CITY OF ALBUQUERQUE

February 26, 2015

RE: **Chick-fil-A**
1600 Gibson Blvd SE
Grading and Drainage Plan
Engineers Stamp Date 12/15/14 (M15-D012C)

Based upon the information provided in your submittal received 2/23/2015, the above referenced Grading and Drainage Plan cannot be approved for Grading Permit or Building Permit until the following comments are addressed.

Sheet
C-3.3

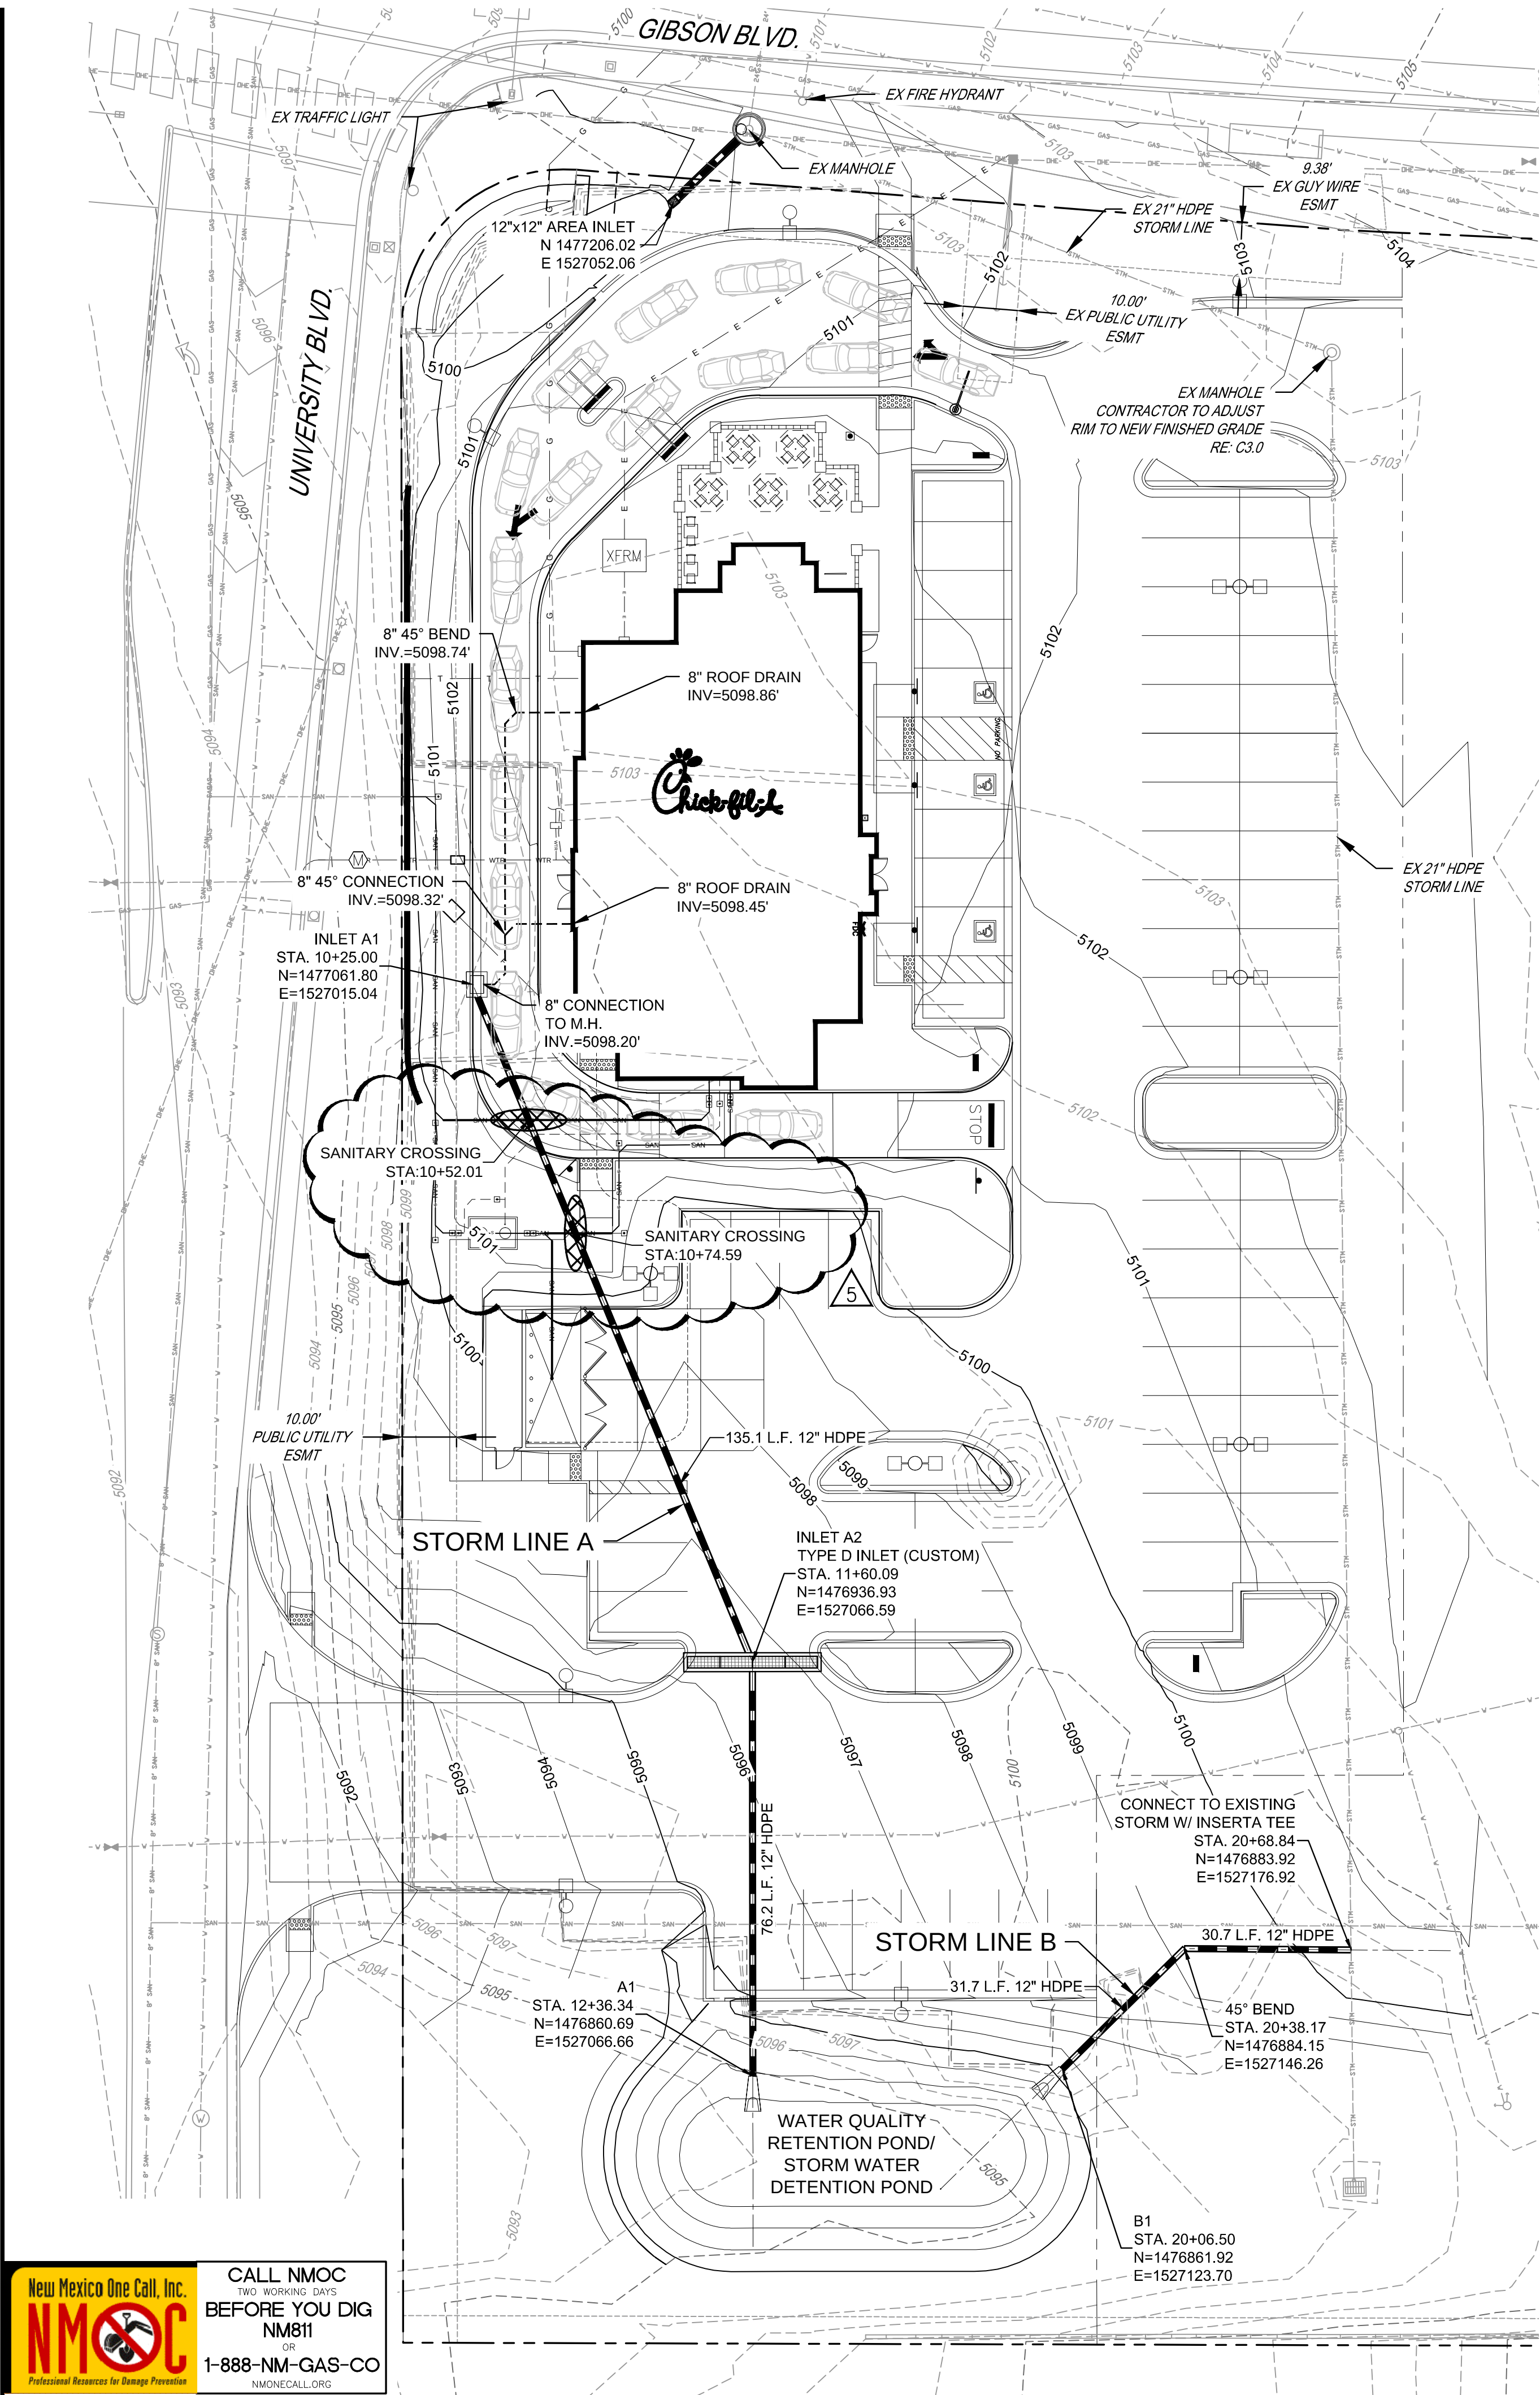
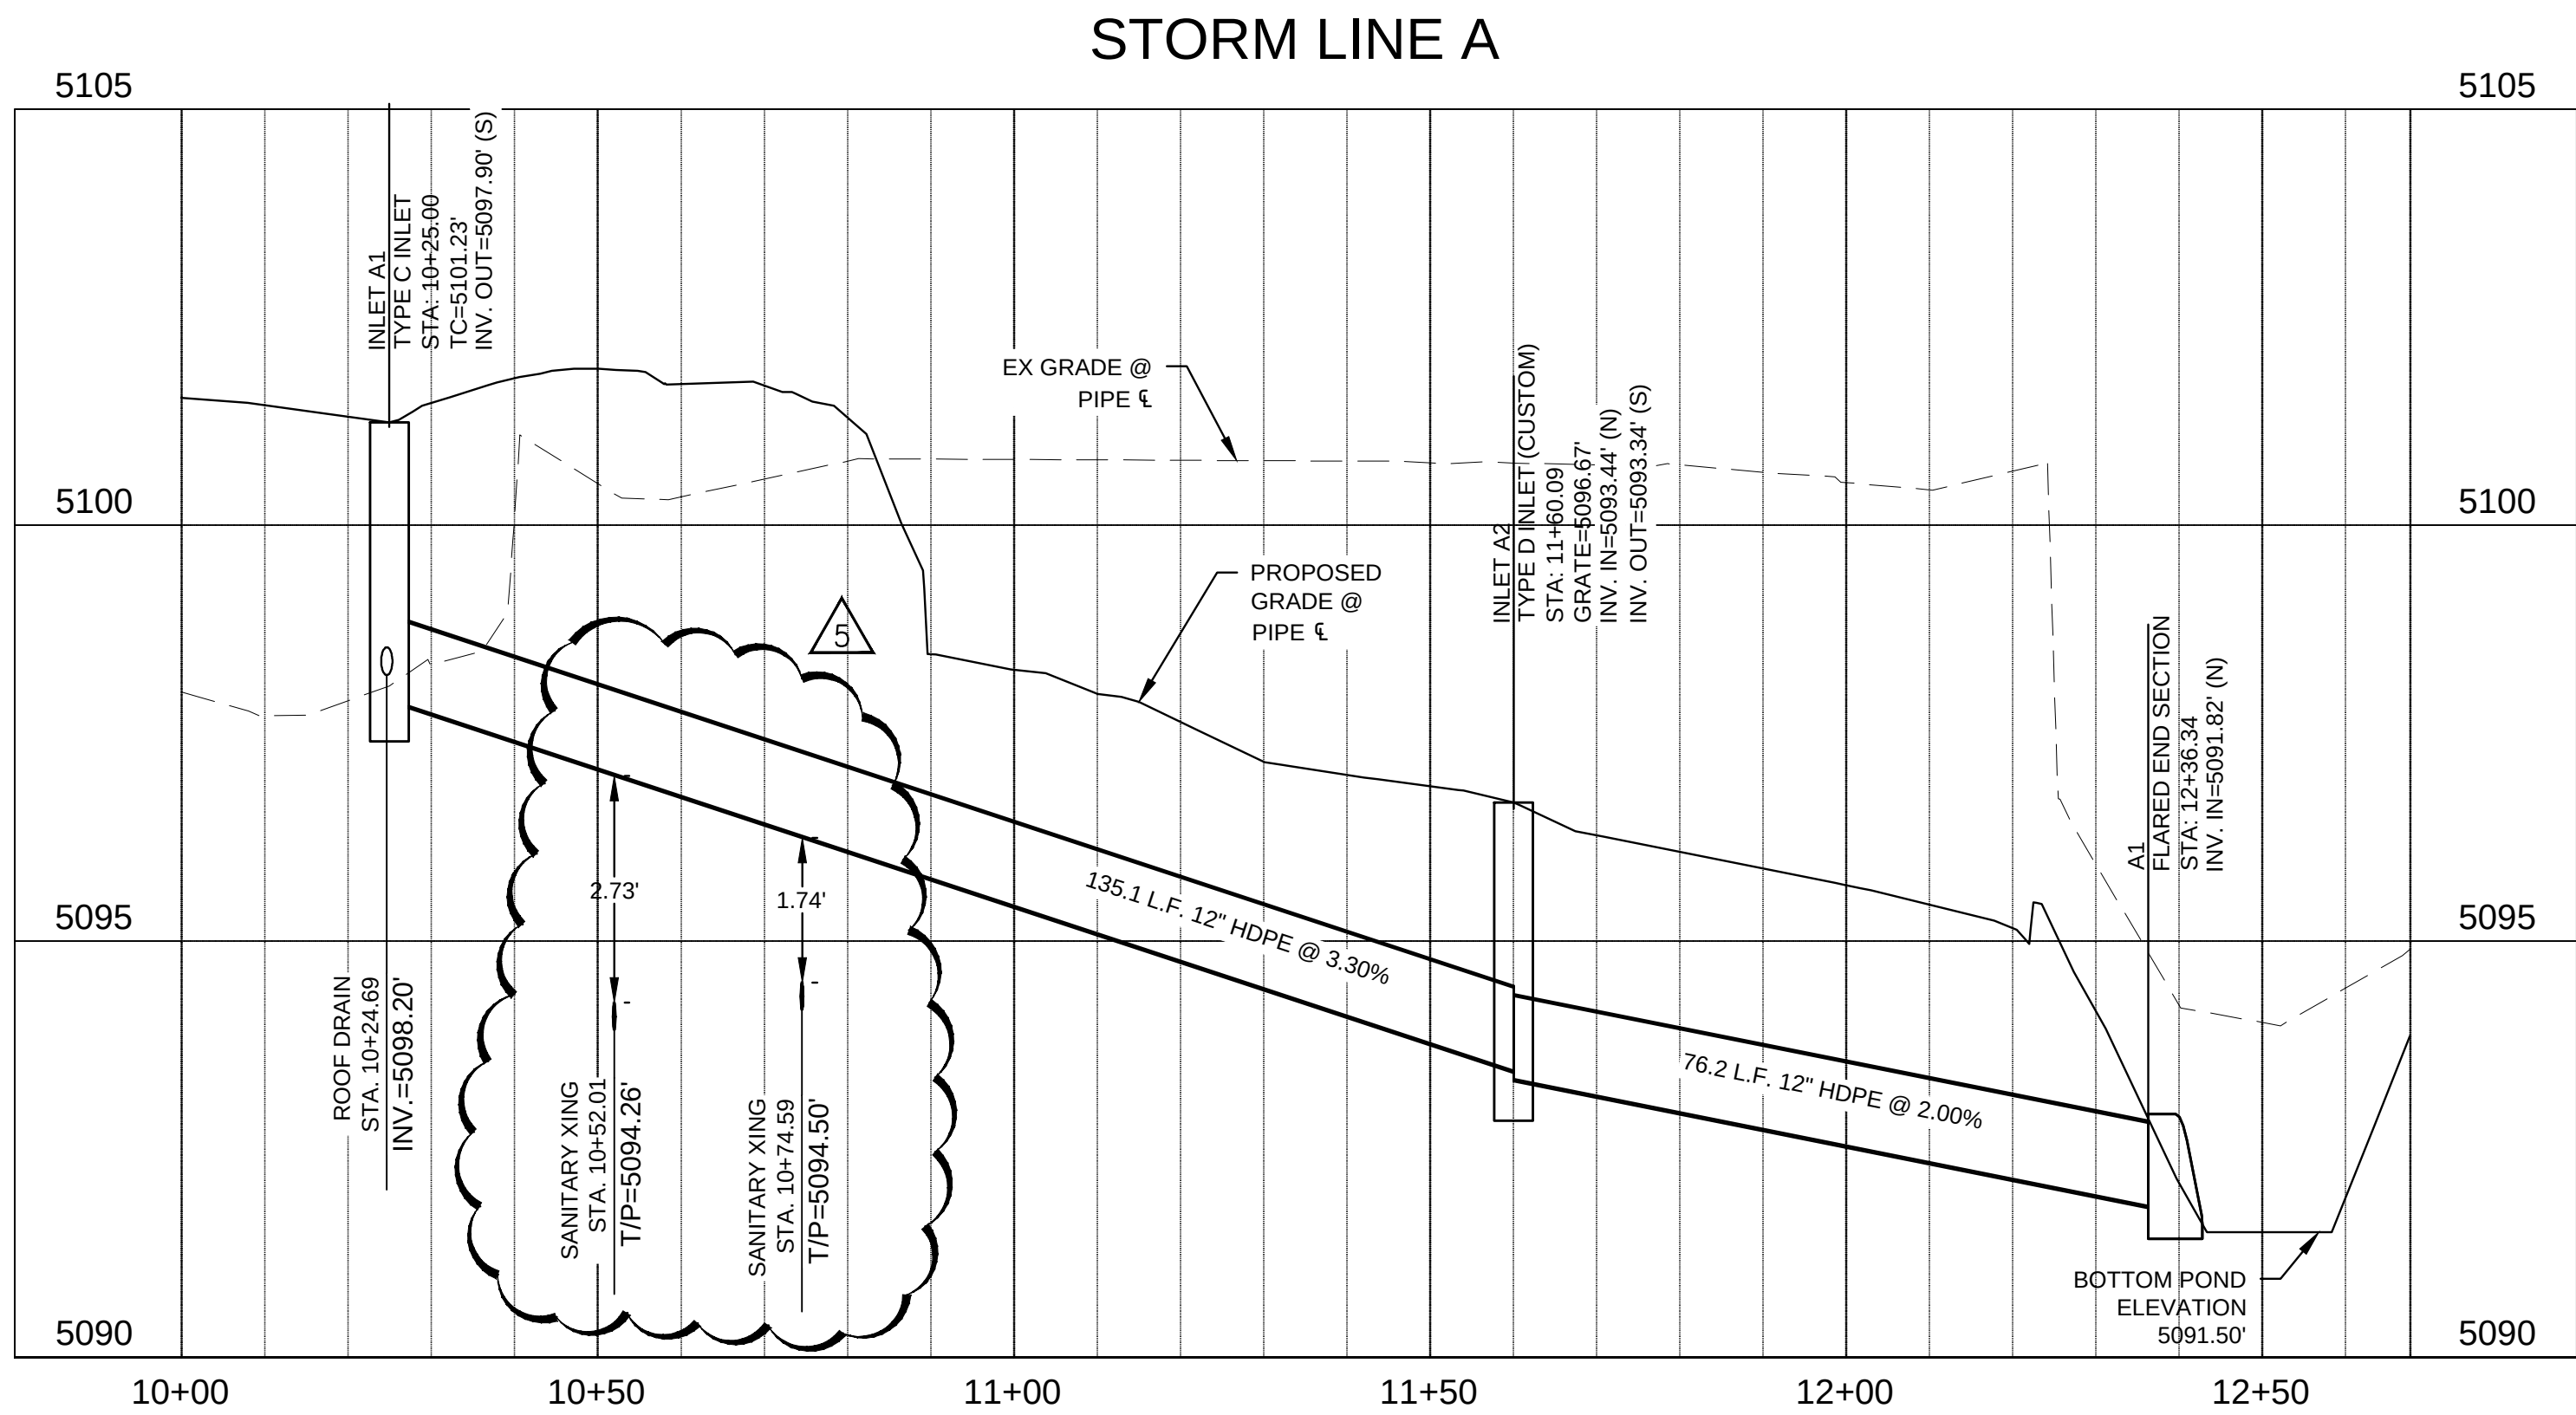
- The plan would be easier to review if sheets C-3.0 & C-3.1 or provide build notes on sheet C-3.0 to get rid of Sheet C-3.1. The storm plan can also be added to sheet C-3.0 and the profiles can be reduced and added to the basin map. Sheet C-3.3 can be deleted if references to these profiles are made on the sheet C-3.0. Also, when time comes to submit for Certificate of Occupancy, fewer sheets will need to be certified.
- Basin B-1 needs to flow through a first flush retention pond before leaving the site.
- What is the purpose of storm drain line B?
- There appears to be a ponding area in the drive up lane.
- An SO-19 permit may be required, depending on if the stub from Gibson Blvd. was extended/built into this site.
